CITY OF ALBUQUERQUE

November 6, 2017

**Re: Floor and Decor
4930 Pan America
Traffic Circulation Layout
Architect's Stamp 10-11-17 (F17D032)**

<b>PROJECT TITLE</b> FLOOR AND DECOR PAN AMERICAN FREEWAY ALBUQUERQUE, NEW MEXICO	<b>PROJECT MANAGER</b> STEPHEN DUNBAR, AIA	<b>JOB NO.</b> FD-1	<b>DRAWN BY:</b> XXX
<b>SHEET TITLE</b> SITE PLAN FOR BUILDING PERMIT	<b>DATE:</b> 9/5/11	<b>SCALE:</b> RE: SCALE	<b>AS101</b>

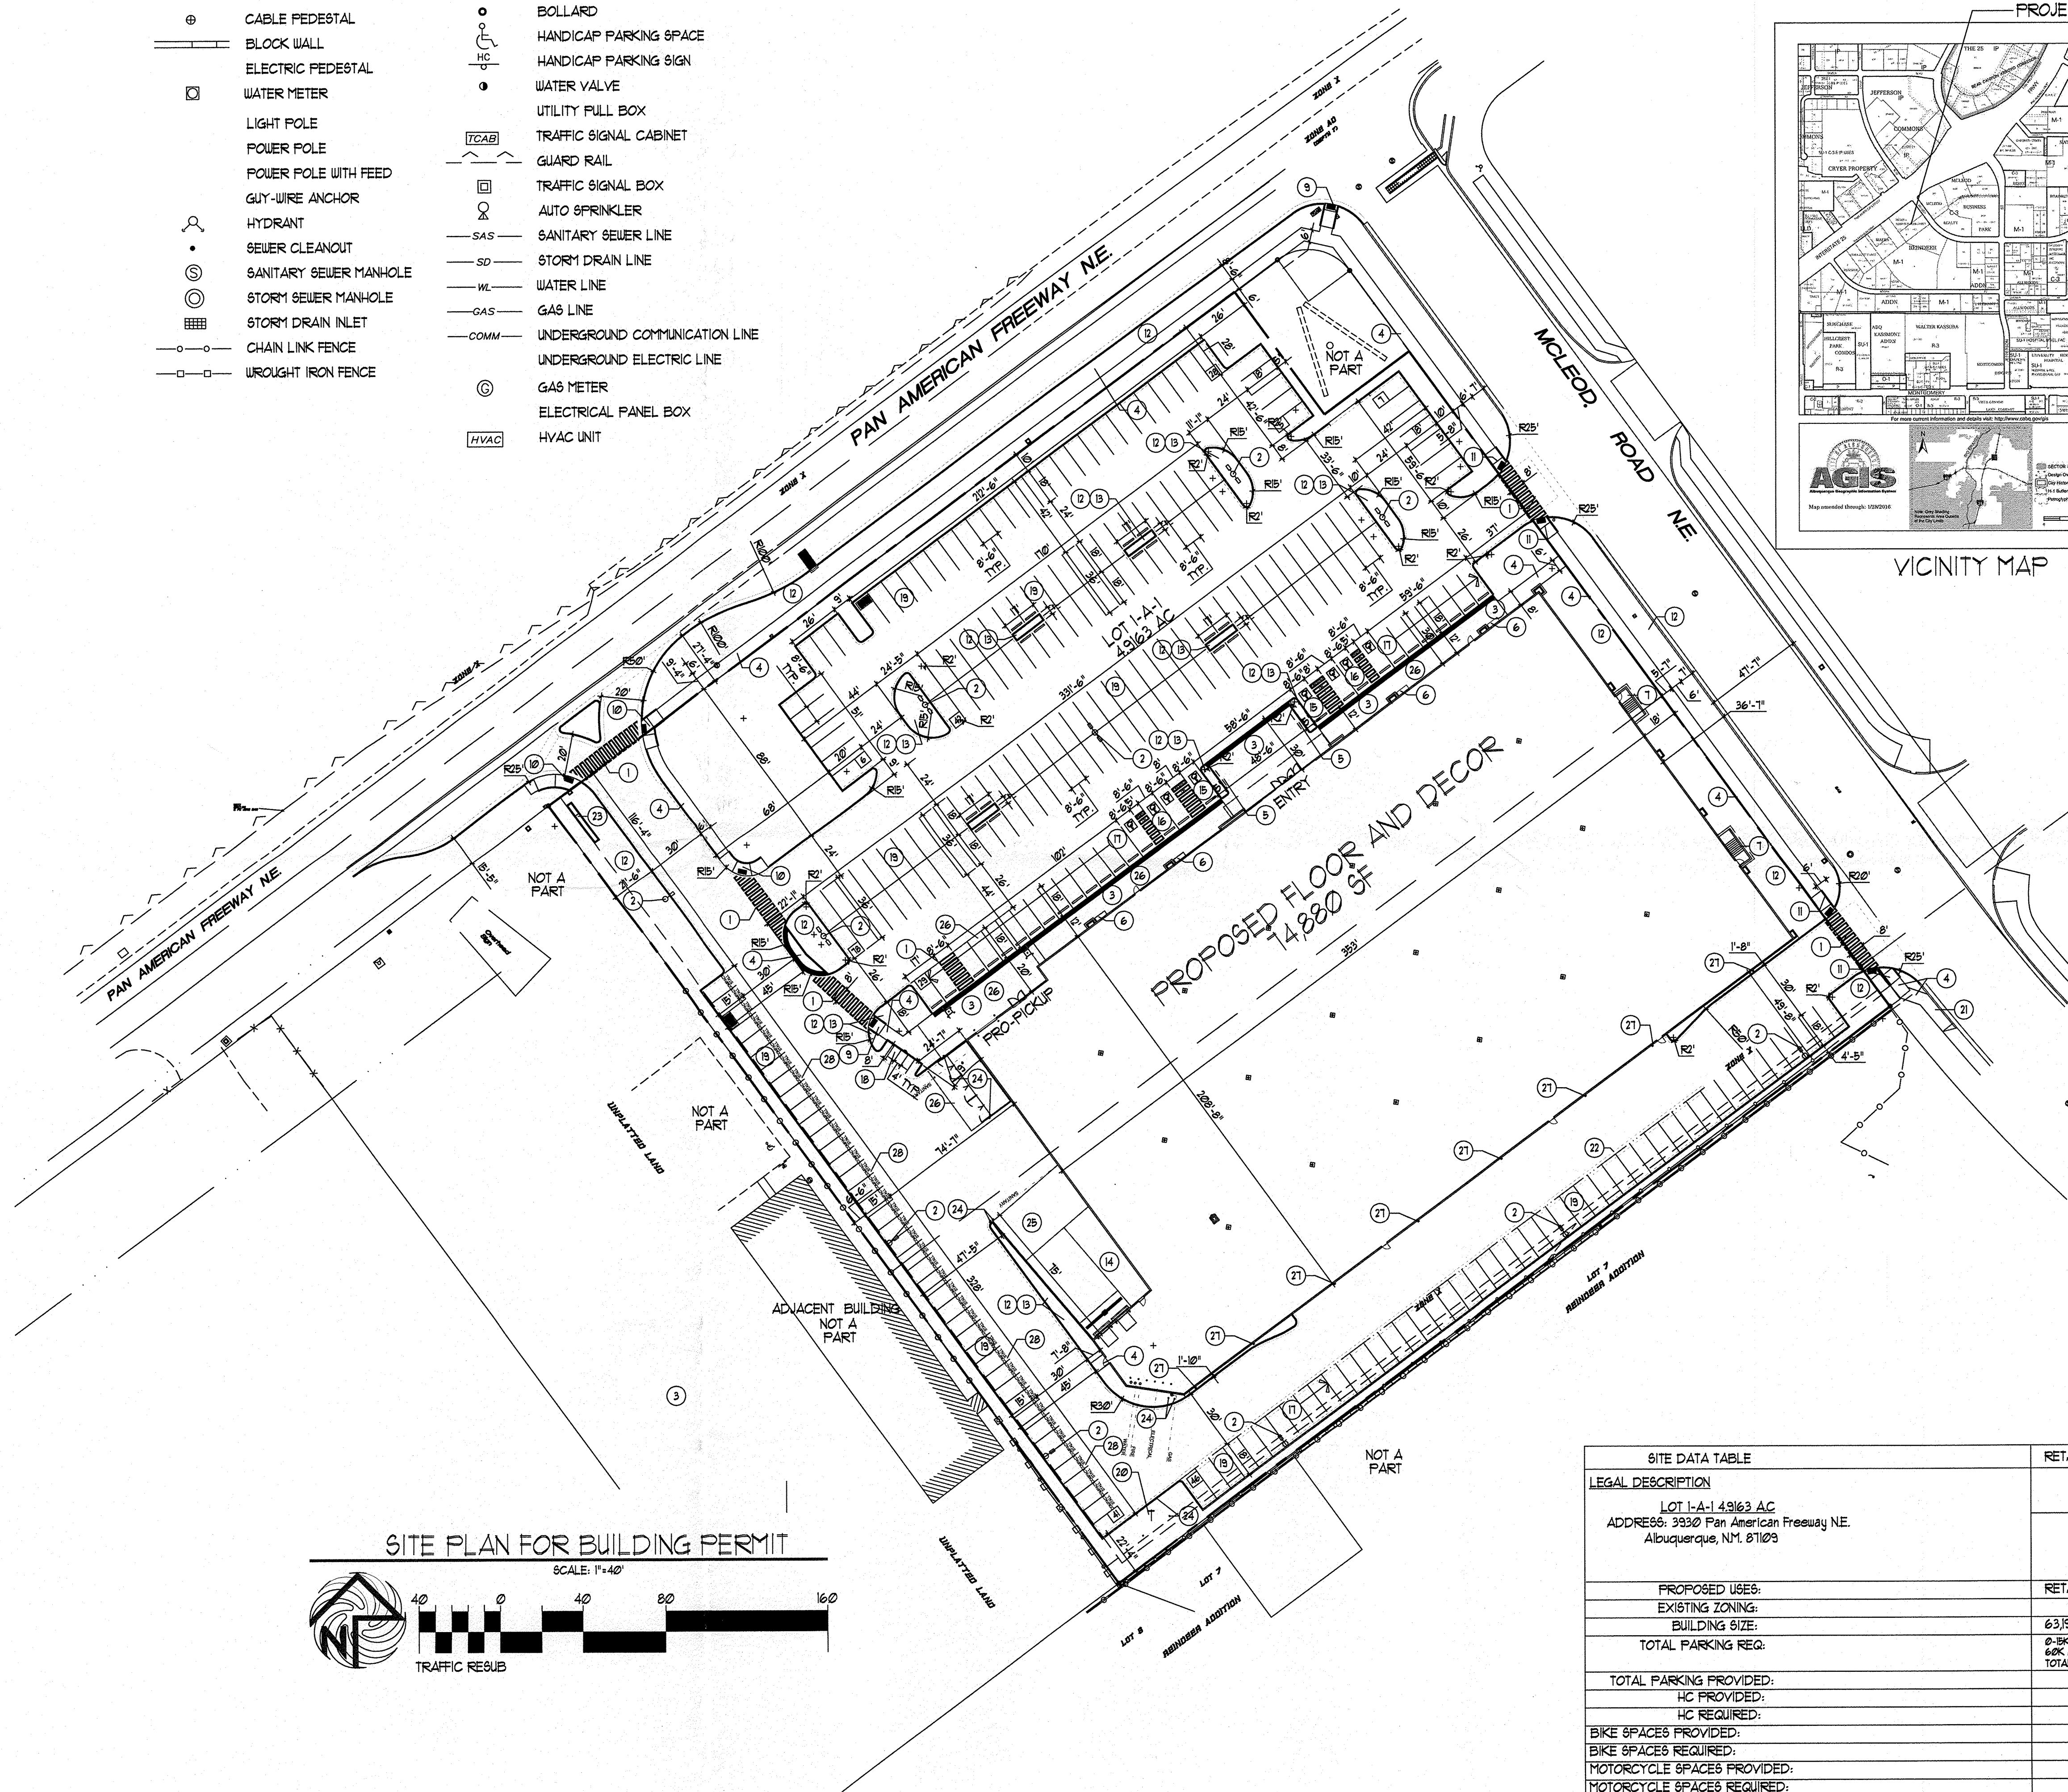
1. All sidewalks along streets should be placed at the property line.
2. Label the compact parking spaces by placing the words "**COMPACT**" on the pavement of each space.
